**WELWYN HATFIELD BOROUGH COUNCIL
ASSISTANT DIRECTOR (PLANNING)**

Application No: 6/2023/1018/HOUSE
Location: 55 Longcroft Lane Welwyn Garden City AL8 6EB
Proposal: Erection of a garden room to rear garden to use as a home office and gym
Officer: Ms Jessica Fuller

Recommendation: Granted

Proposed Site Plan 1:500

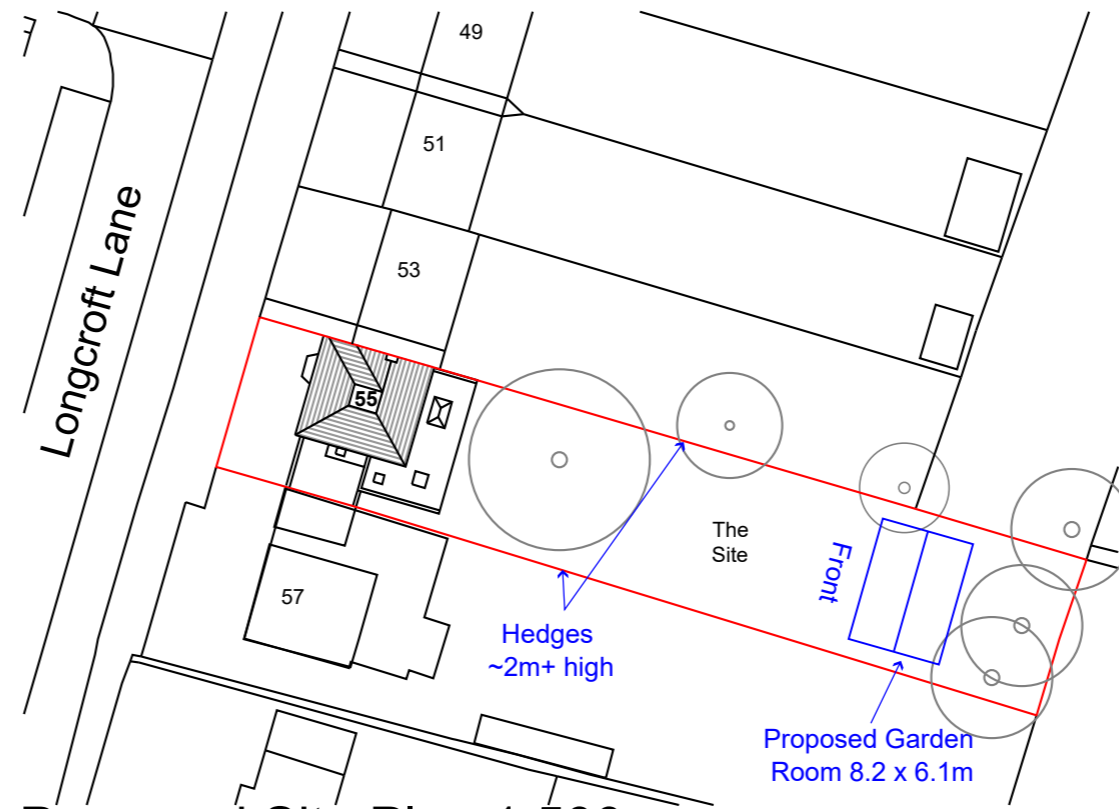
the maximum dimensions above are not exceeded but do not provide any more information about whether or not the structure would be permanent or temporary in nature and the plans appear to show it positioned on a concrete slab. However, it is important to emphasise that although this noted, this is an application for planning permission, and it has been assessed on the grounds of the proposal being applied for as a garden building that requires permission. For these reasons, whether or not it would technically meet the definition of a caravan is not crucial to determining the application.

# Page 1 Proposed Floor Plan

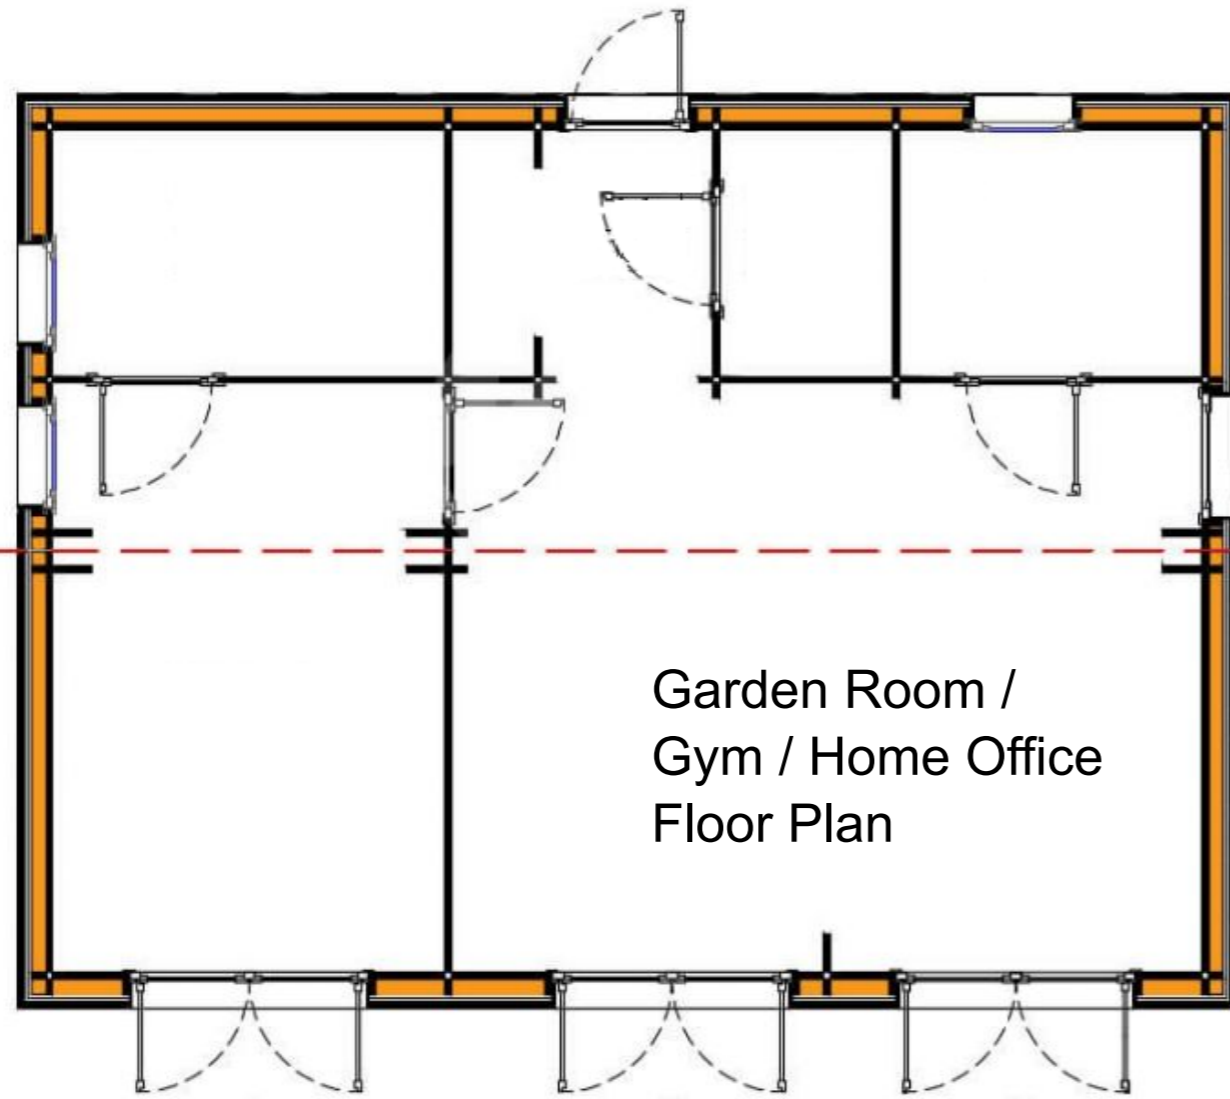
The proposed structure would share the same vehicular and pedestrian access as the main house, and it would not have its own curtilage. It would comprise of a garden room/gym/home office. Whilst the proposed plans do not indicate the internal room layouts, these uses are described on the floor plans and on the form. The use of the proposed outbuilding in the manner described in the application would therefore be a use that is part and parcel of the use of the existing dwellinghouse. An informative will be added to the decision notice to remind the applicants that the outbuilding is for an ancillary/incidental use to the main dwelling only and any use for a separate purpose, such as a separate dwelling or a business/commercial use, would require a separate grant of planning permission.

1. You are hereby advised that the garden room hereby approved is for use for purposes ancillary to the residential use of the dwelling known as 55 Longroft Lane and any use for a separate purpose, such as a separate dwelling or a business/commercial use, would likely require a separate grant of planning permission.

Page 3 - Proposed Side Elevations

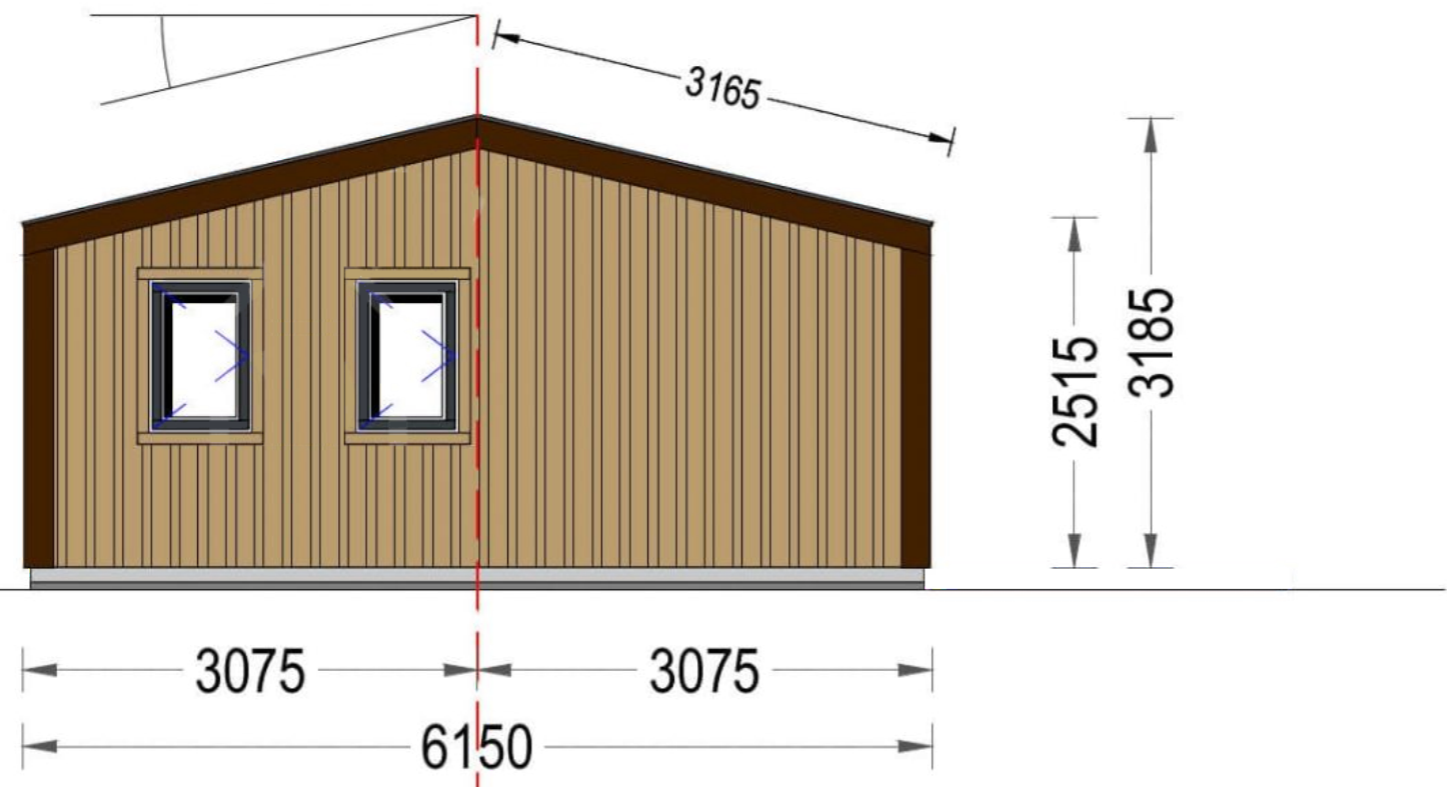
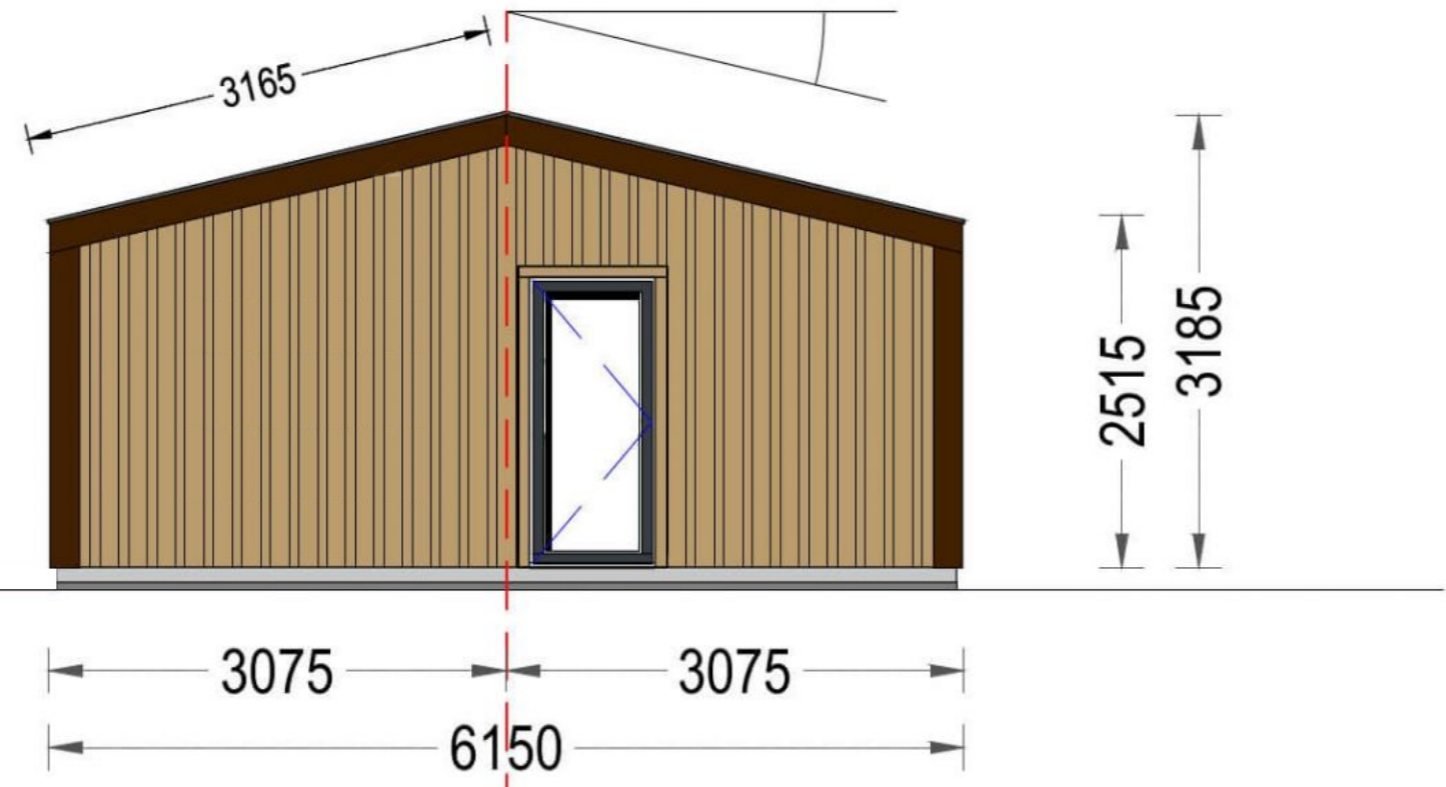
The proposed garden room would measure approximately 8.2m x 6.1m with a maximum height of 3.2m to the ridge, and 2.5m to the eaves. It would feature a pitched roof with three double doors on the front elevation, which would face into the rear garden of the application site. It is noted the conservation officer has commented on the proposed materials, setting out how they would not be in keeping with the characteristic material palette of the Conservation Area. However, the comment concludes that the proposed building would be of low visibility and would result in the very lowest level of less than substantial harm to the Conservation Area.

The exact materials of the outbuilding are unclear as the proposed plans appear to indicate wood cladding of a natural timber colour and grey roof tiles, whereas the application form states that the walls would be either wood or recycled plastic composite cladding in grey. Other materials are described on the application form as a black felt roof (which again differs to the submitted plans), and grey UVPC windows and doors.

1. No development above ground level (beyond slab level) shall take place until full details of any materials to be used in the construction of the external surfaces of the building hereby approved have been submitted to and approved in writing by the Local Planning Authority. The development shall be implemented using the approved materials and subsequently, the approved materials shall not be changed.
